Final Plat Drawings_v1 redlines.pdf Markup Summary 1-11-2022

BENT GRASS EAST COMMERCIAL FILING NO. 3  
JOB NO. 2177.64  
NOVEMBER 30, 2021  
SHEET 1 OF 2

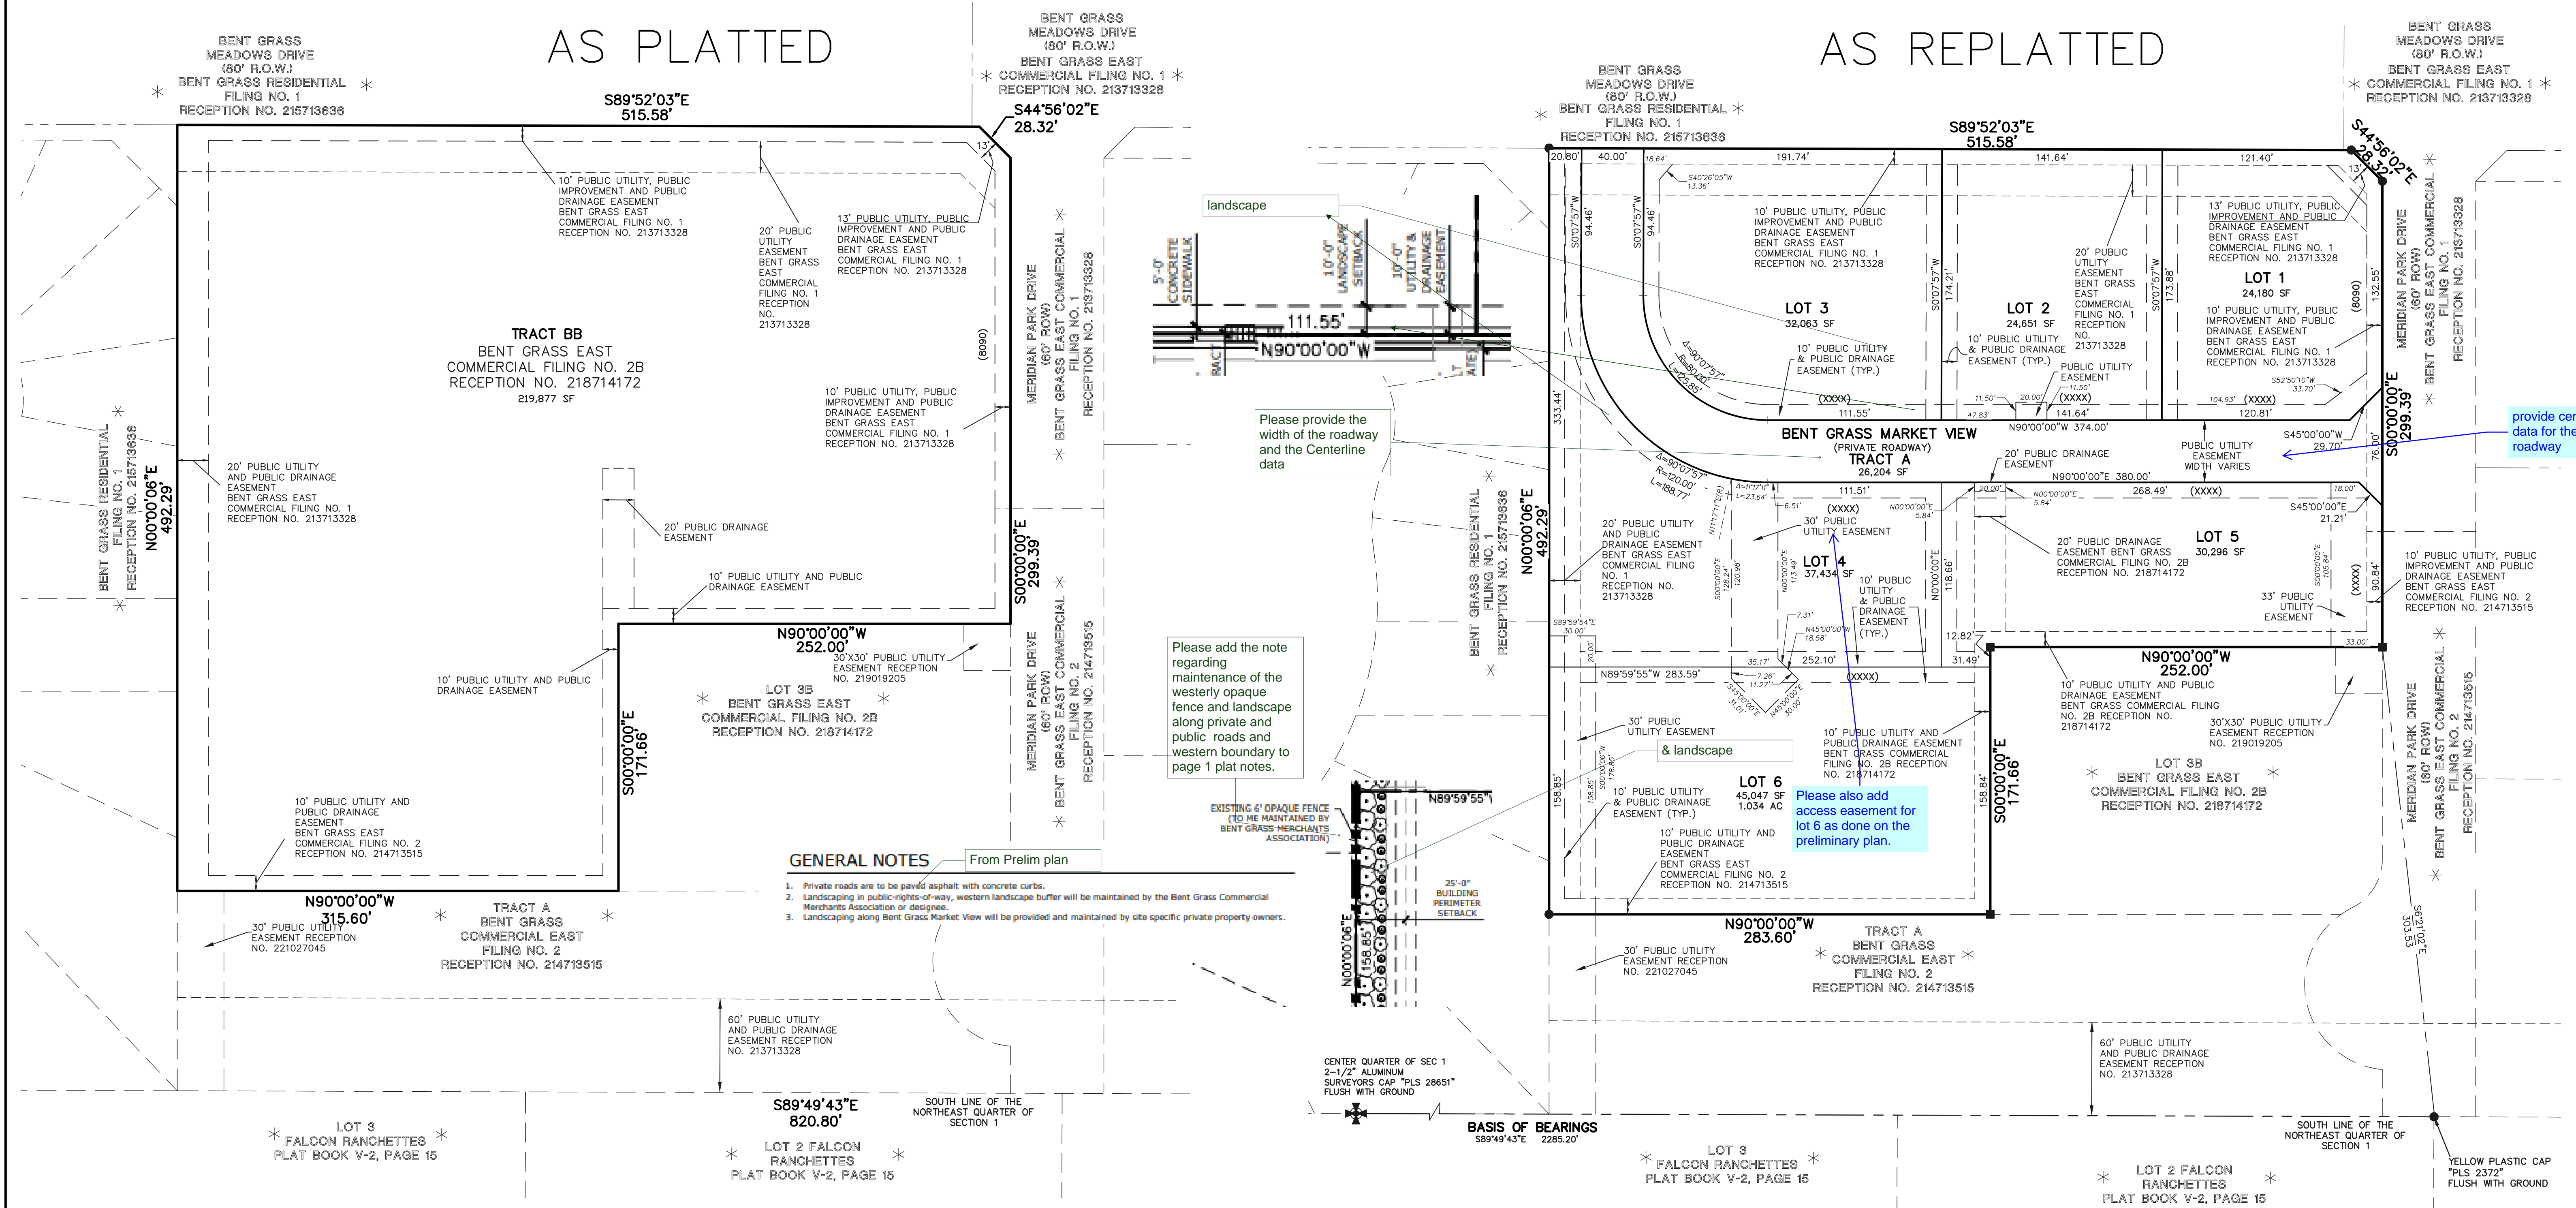
Please also add access easement for lot 6 as done on the preliminary plan.

provide centerline data for the proposed roadway

Please provide the width of the roadway and the Centerline data

Please add the note regarding maintenance of the westerly opaque fence and landscape along private and public roads and western boundary to page 1 plat notes.

REVISED

REVISED

REVISED

REVISED
